FINAL PLANS

CHANGE ORDERS:

Texas Department of Transportation				
DESIGN	FED. RD. DIV. NO.	FEDERAL AID PROJECT NO.		HIGHWAY NO.
GRAPHICS	6	CM 97(449)		MH
CHECK	STATE	DISTRICT	COUNTY	SHEET NO.
CHECK	TEXAS	DALLAS	DALLAS	1A
CHECK	CONTROL	SECTION	JOB	
	8050	18	034

PAVING AND DRAINAGE PLAN/PROFILE SHEET
 BELT LINE ROAD
 STA 87+43.34 TO STA 90+67.34
 ADDISON, TEXAS

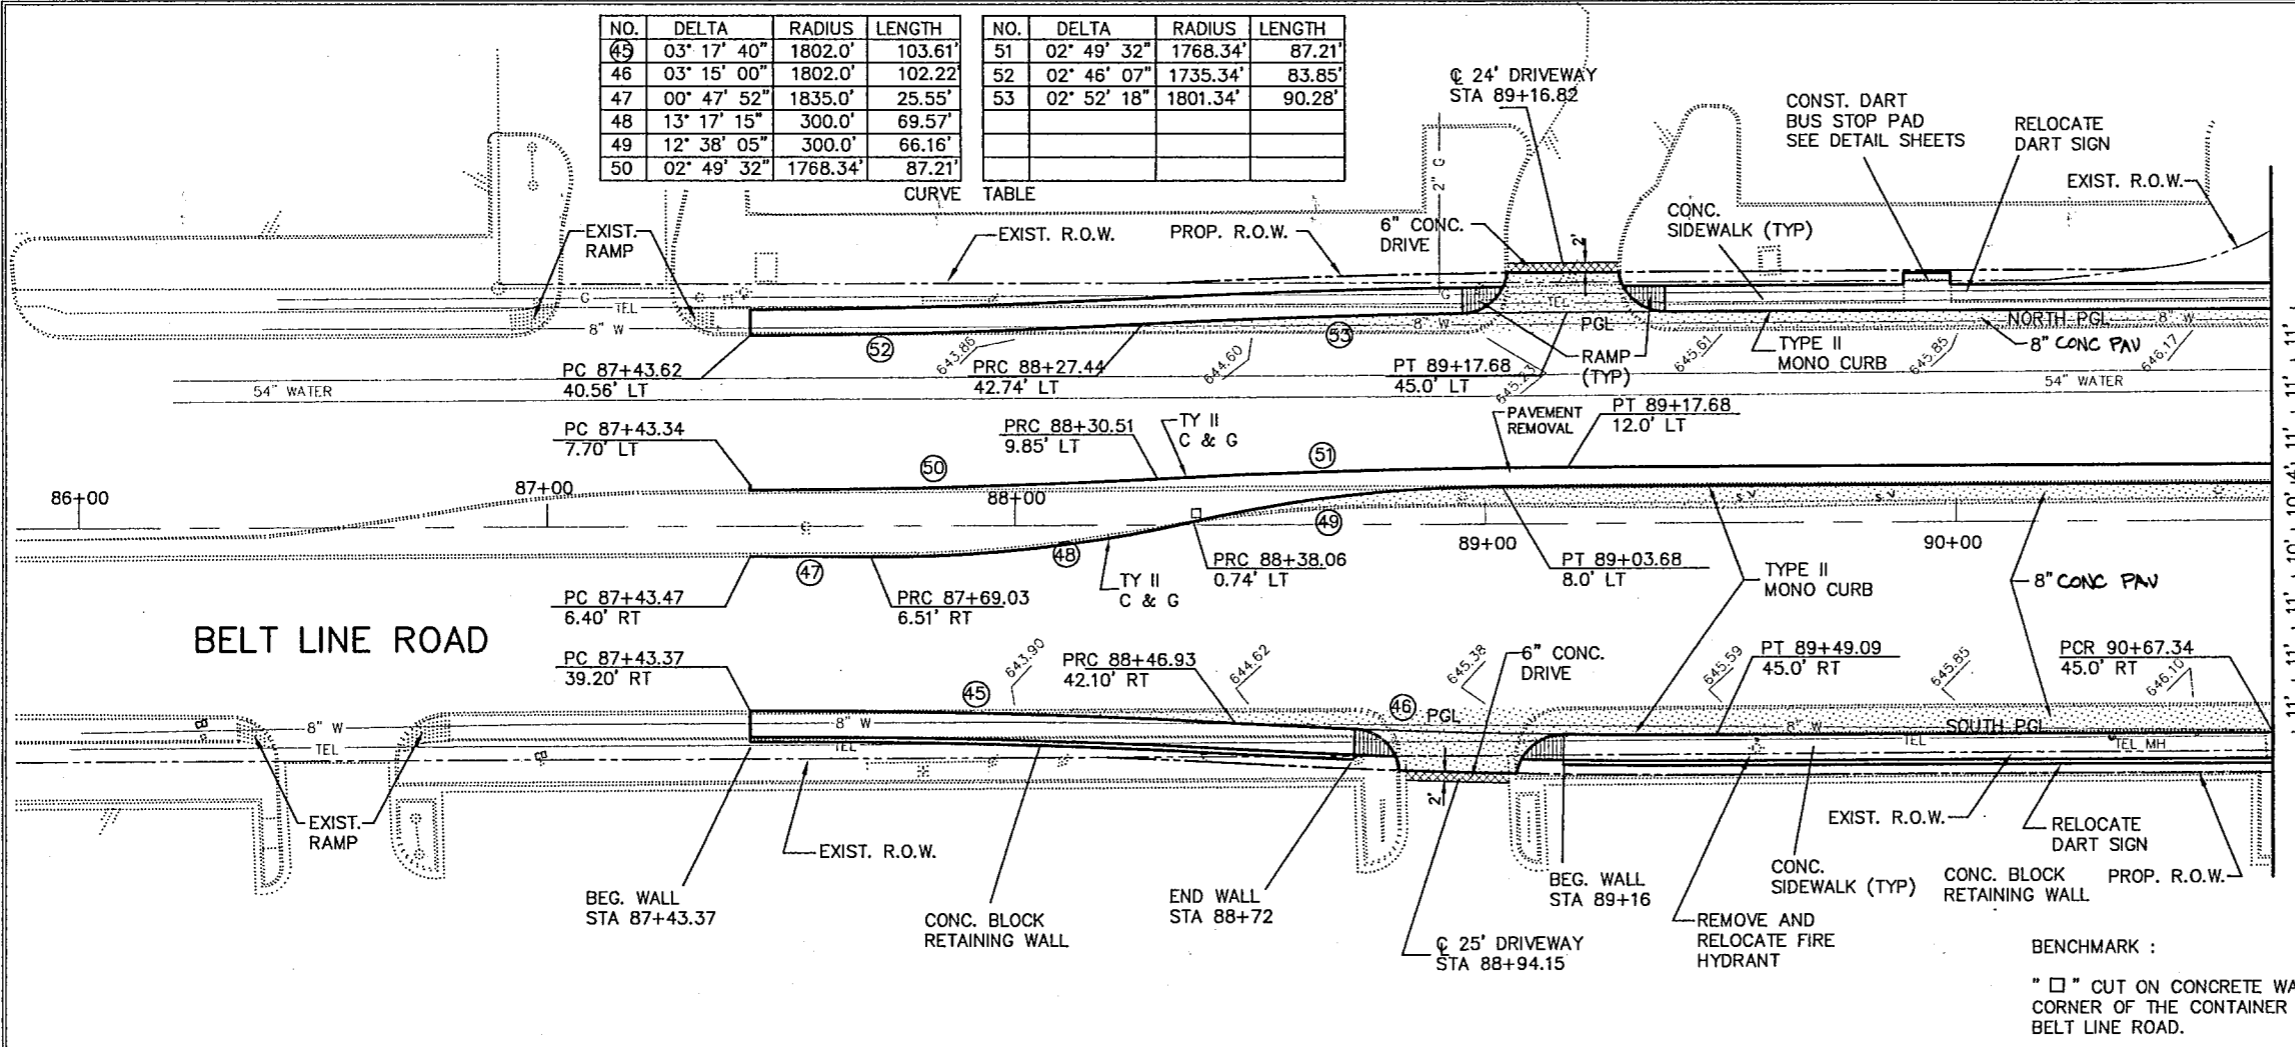
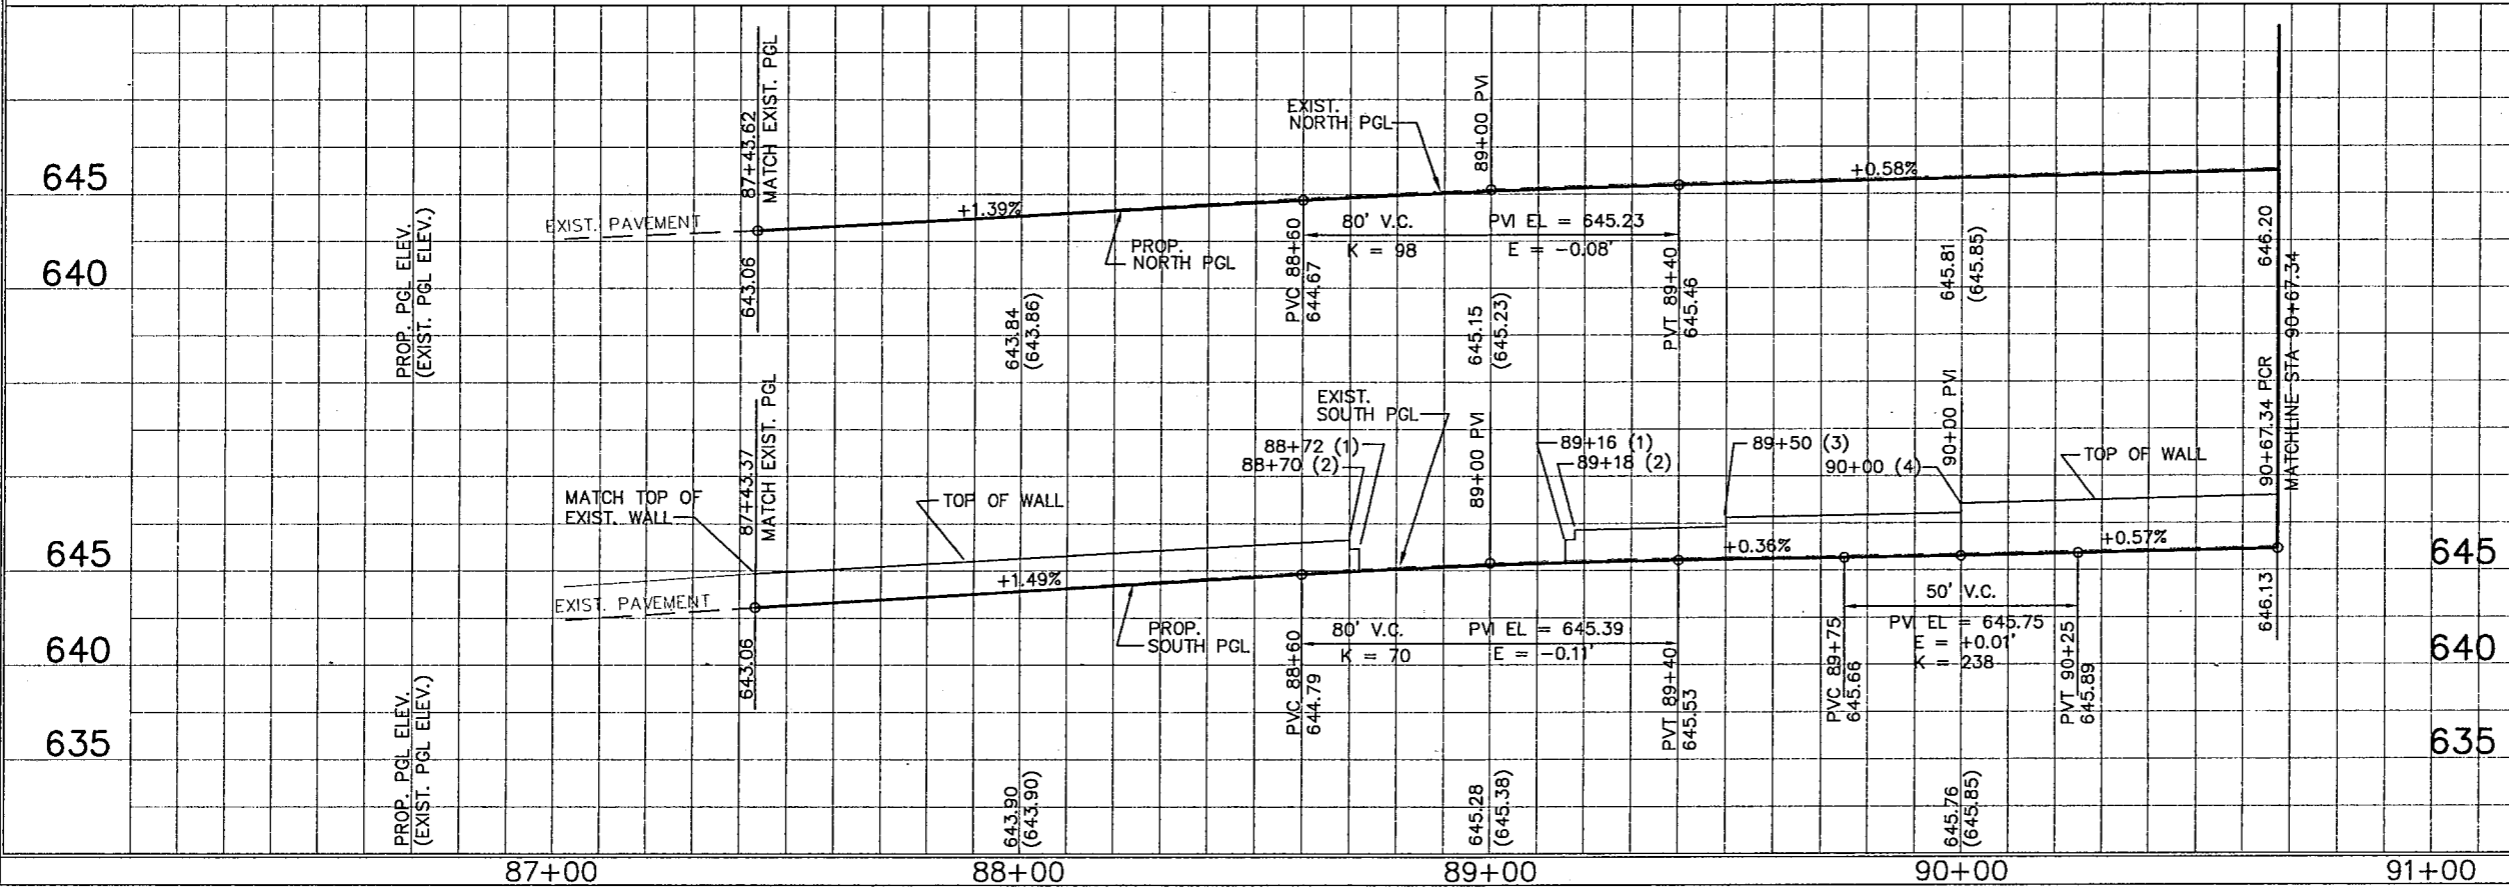
- CHANGE ORDER NO.1 To add revised plan sheets correcting horizontal alignment errors.
- CHANGE ORDER NO.2 Deletes the field office requirement.
- CHANGE ORDER NO.3 To change the pavement marking skip line buttons from plastic to ceramic to match existing conditions.
